**Champions Quarry MOD 2
Biodiversity Offset Strategy**

The Department has considered your modification application (MOD 2), including your proposal to amend the boundaries of the Biodiversity Offset Areas (BOA) and Protected Revegetation Areas (PRA), and further described in your Response to Submissions (RTS). This matter has been the subject of previous correspondence between yourself and the Department, such as in the Department's letter dated 13 January 2015 relating to the Landscape Management Plan and long term security of the offsets. The Department identified inconsistencies between the BOA contained in the Landscape Management Plan and proposed section 88E positive covenant instrument and requested that these be amended to reflect what is approved, as illustrated conceptually in Appendix 6 of project approval 09_0080 (PA 09_0080).

Plan of Biodiversity Offset Areas

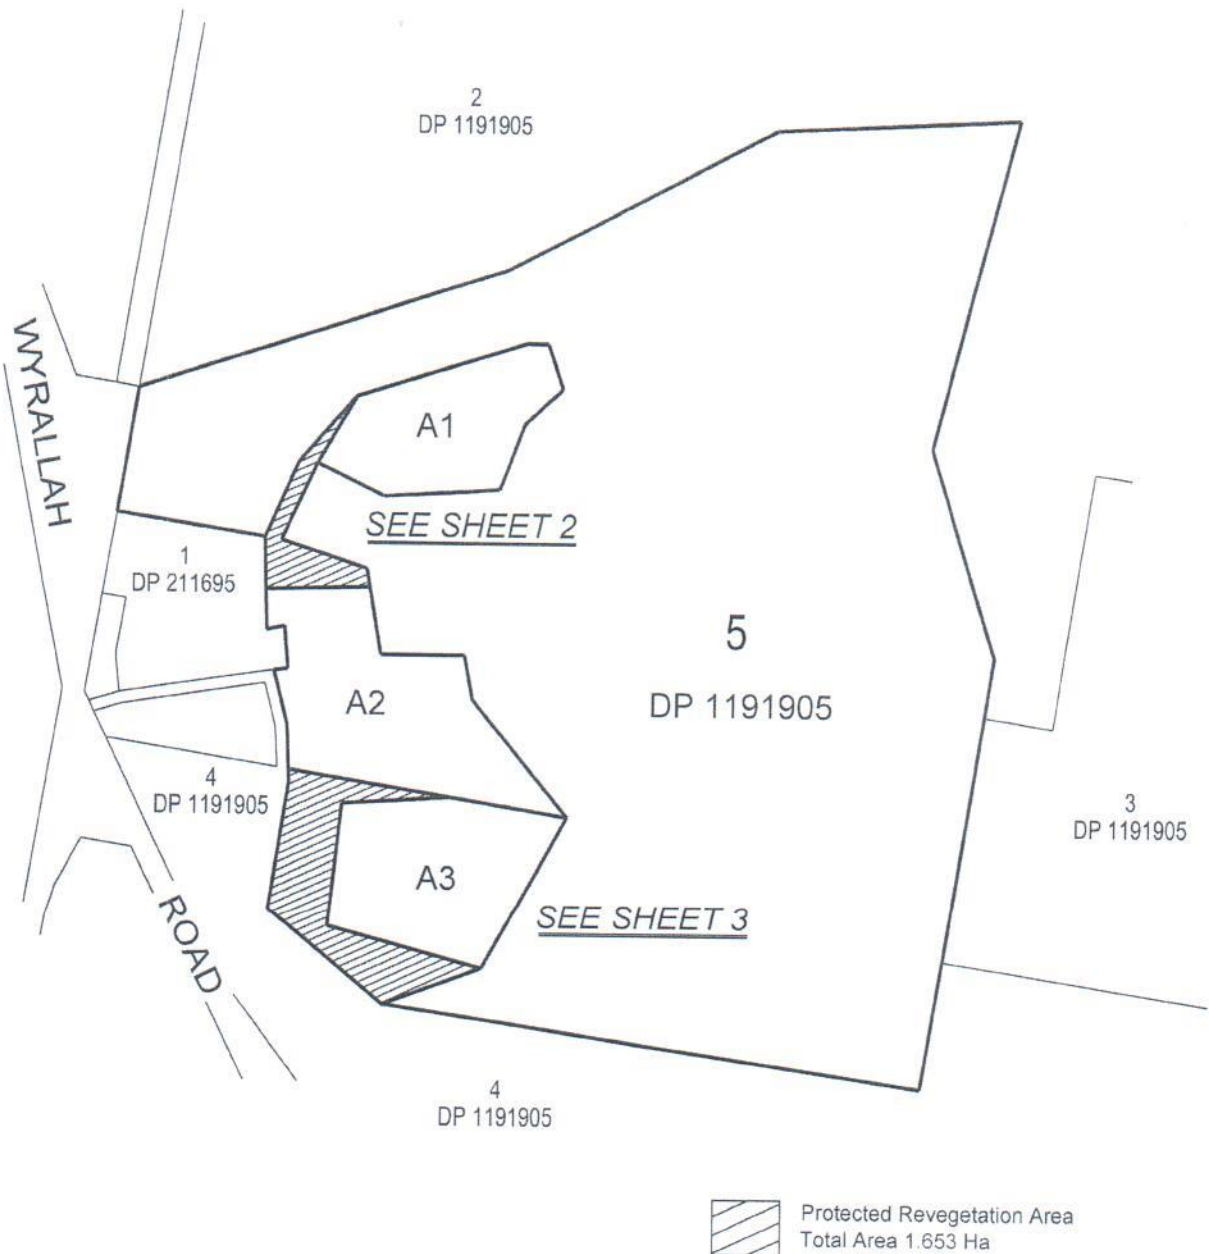
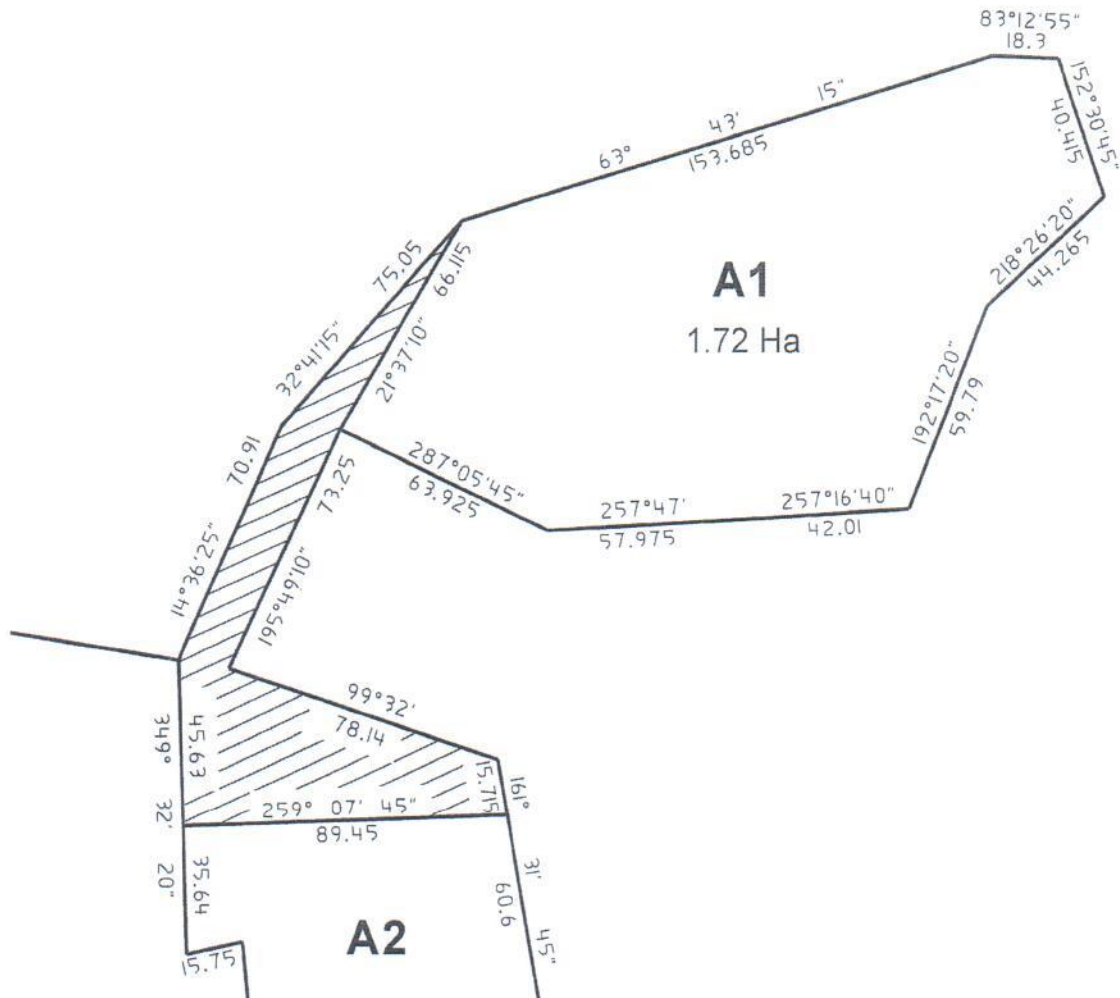
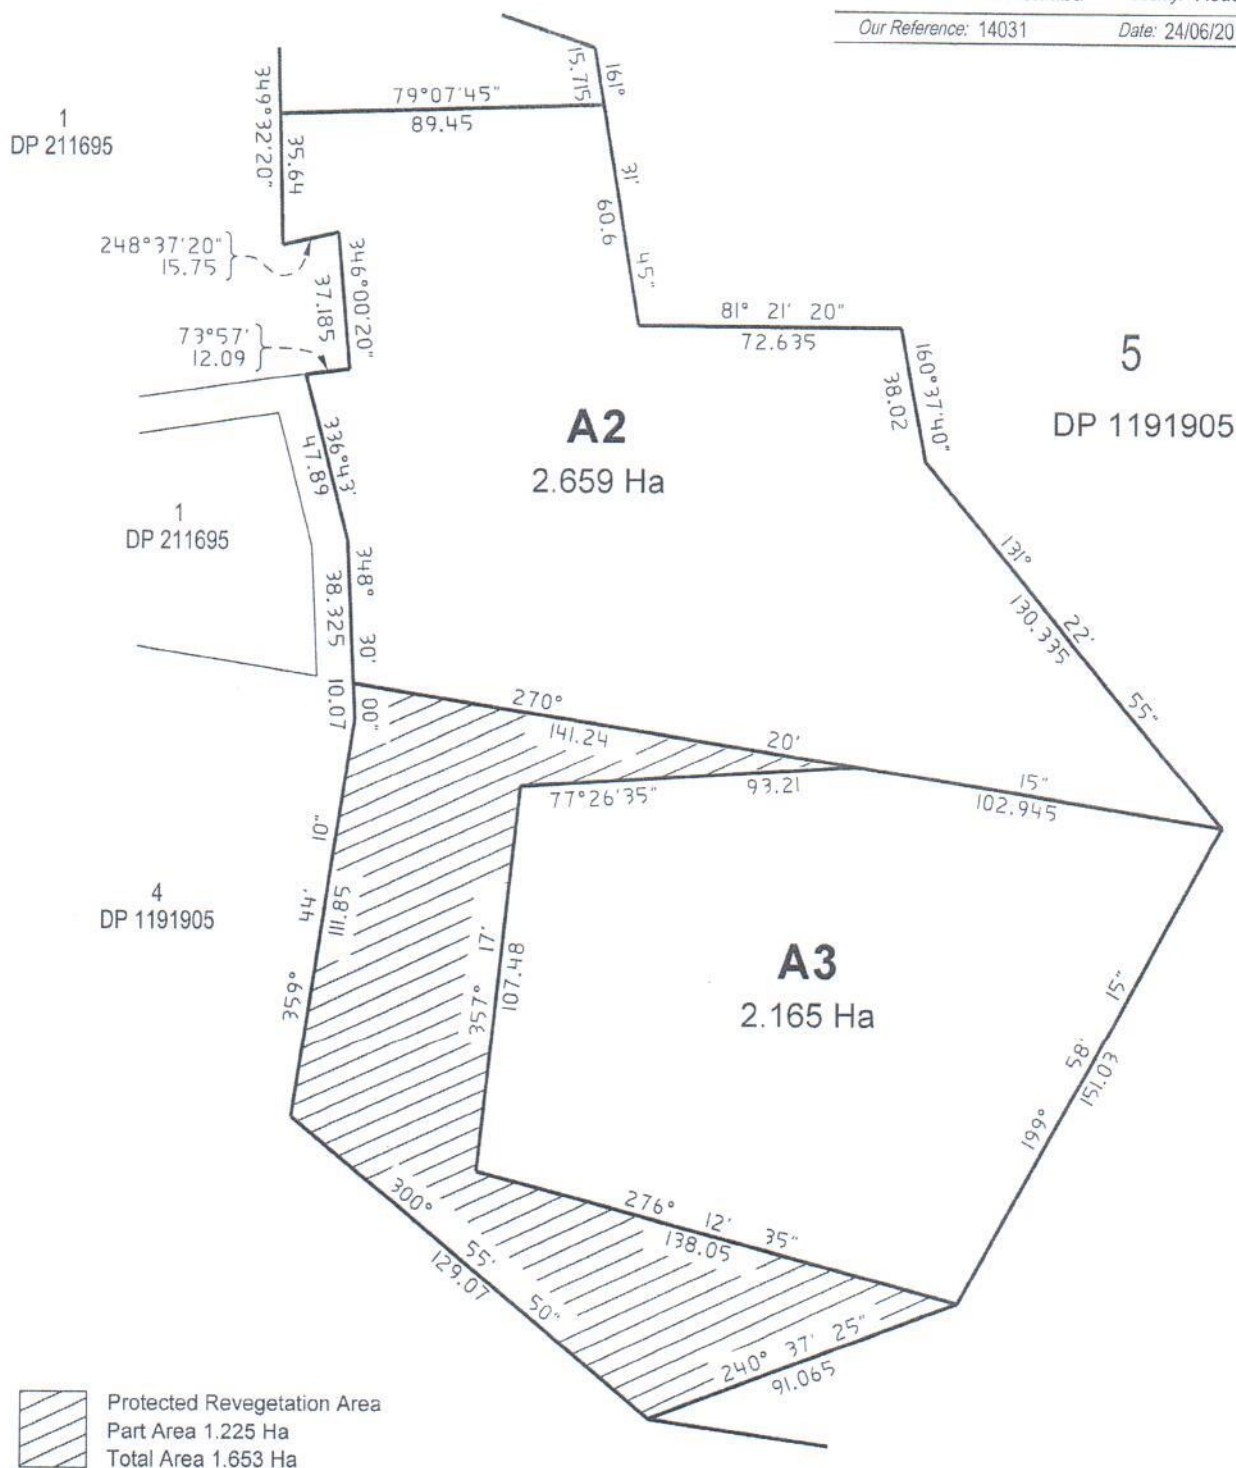
The revised areas proposed in MOD 2 satisfy the minimum area requirements of condition 40. However the proposed boundaries would result in:

- the BOA would contain larger areas of lower quality vegetation;
- the PRA would contain larger areas of higher quality vegetation and less area suitable for revegetation;
- areas of higher quality vegetation that are currently identified in PA 09_0080 as being contained within the BOA would no longer be contained within either the BOA or the PRA; and
- overall there appears to be a reduction in the total area of higher quality vegetation protected.

From a discussion between Cath Champion and Michelle Kirkman from the Department on 3 May 2016, we now understand that the key drivers for the location of the proposed boundaries are the maintenance of a 50 metre buffer from the extraction areas (to satisfy condition 37) and the alignment of the western boundaries with existing cadastre boundaries and existing fencing, as well as the straightening of boundary lines for ease of fencing. We note that condition 37 requires *"that the edge of the Southern Extraction Area is setback at least 50 metres from the mapped Dry Rainforest/Lowland Rainforest Endangered Ecological Community (EEC) on site."* Providing a 50 metre buffer between the BOA boundaries and the extraction area does not satisfy this condition because the buffer needs to be provided to the actual Dry Rainforest/Lowland Rainforest EEC.

The Department requires that Champions Quarry revise the offset boundaries such that the following is achieved:

- the minimum size requirements for the BOA and PRA contained in condition 40 are met or exceeded;
- the BOA contain the higher quality vegetation on site;
- the PRA contain the lower quality vegetation on site, suitable for revegetation works;
- Area 1 includes all of the higher quality vegetation consistent with what is currently identified in Appendix 6 of PA 09_0080;
- Area 2 includes the pocket of higher quality vegetation in the north easterly corner consistent with what is currently identified in Appendix 6 of PA 09_0080;
- A more substantial corridor is provided to connect Areas 1 and 2, expanding towards the south east from the location proposed in MOD 2 and, if feasible, encompassing the dam that has been constructed between Areas 1 and 2.

The Department is willing to consider reducing the buffer required of condition 37 to enable this to be achieved without compromising the extent of the Southern Extraction Area. In addition, assuming the minimum area requirements of condition 40 is met, the Department would also be willing to consider limiting the BOA and PRA on the western edge to the cadastral boundary and existing fence line.

Please submit a revised figure of the BOA and PRA that satisfy the above requirements, along with appropriate documentation to demonstrate that the minimum requirements of condition 40 have been met. If you would like to discuss this matter further please contact Michelle Kirkman via the details shown above.

Figure 4: Original Proposed Biodiversity Offset Areas and Protected Revegetation Areas

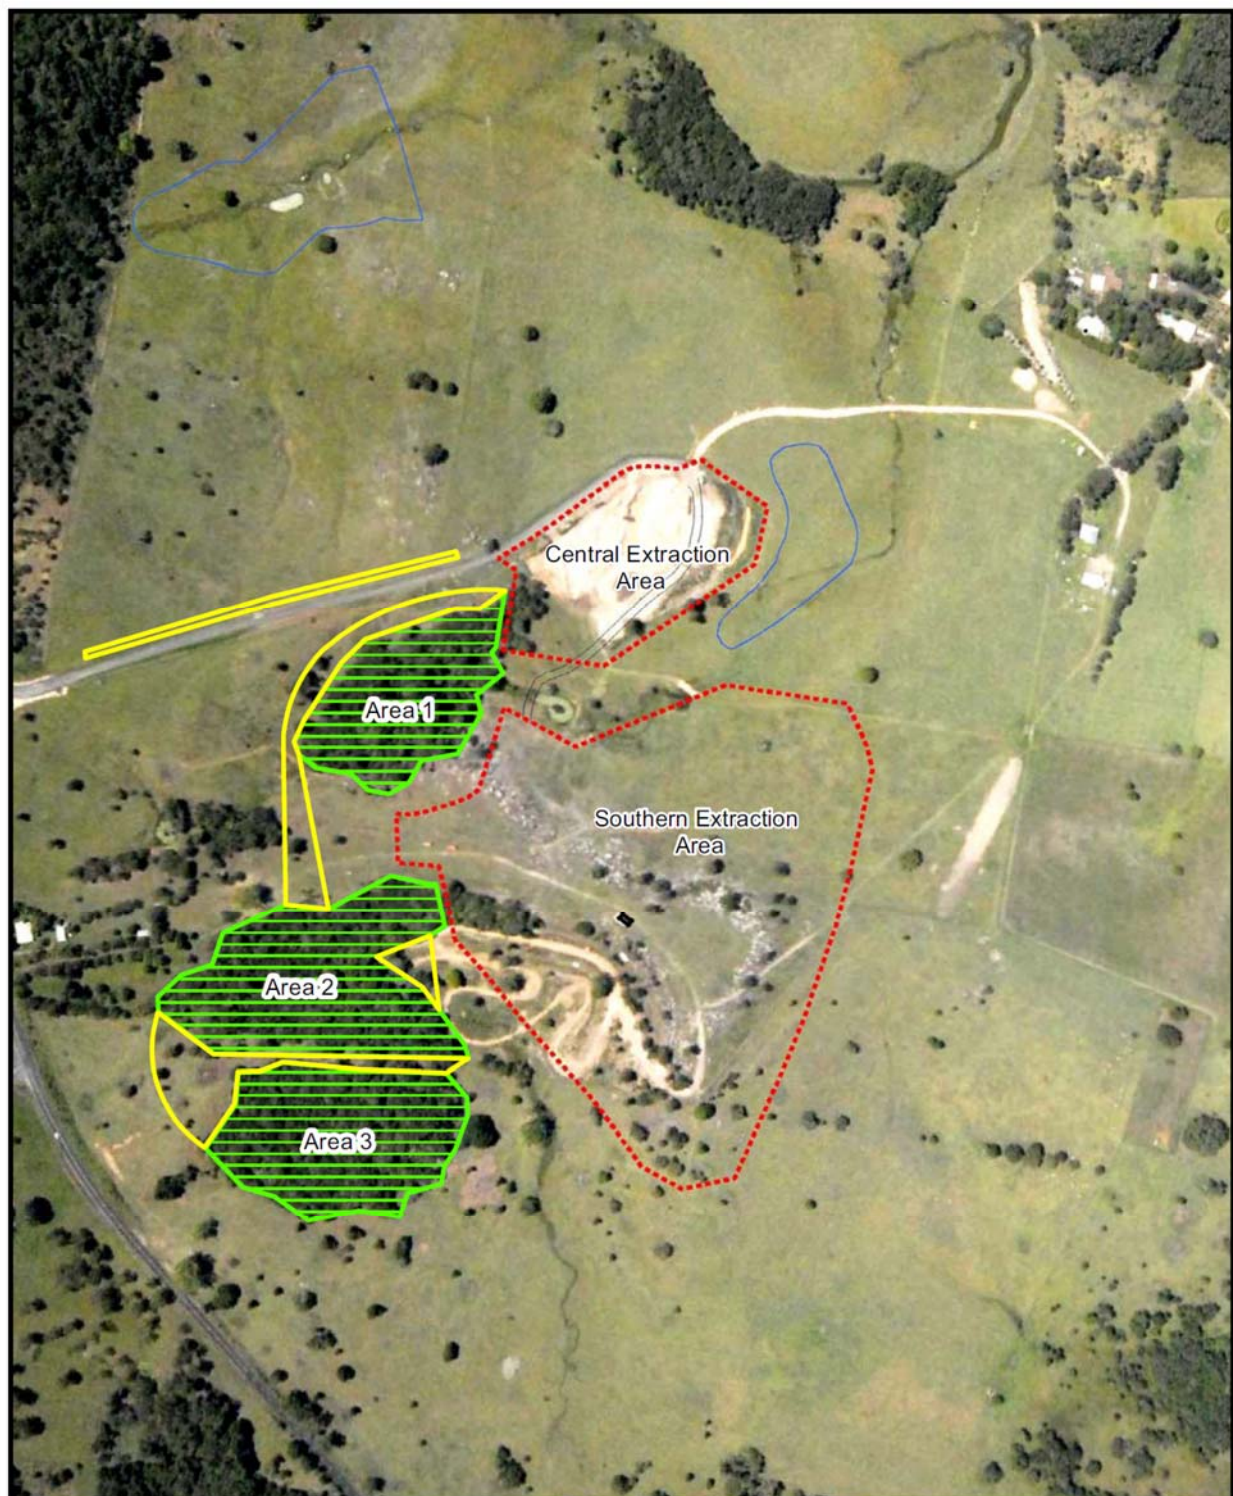
MOD 2 is seeking to amend PA 09_0080 to include the revised BOA and PRA as they were proposed in the Landscape Management Plan and proposed section 88E positive covenant instrument. The Department is not satisfied that the areas as proposed satisfy the intent of the Biodiversity Offset Strategy. The intent is to contain the higher quality vegetation on site within the BOA and the lower quality vegetation on site within the PRA, and for these areas to satisfy the total area in hectares as required of condition 40 of PA 09_0080.
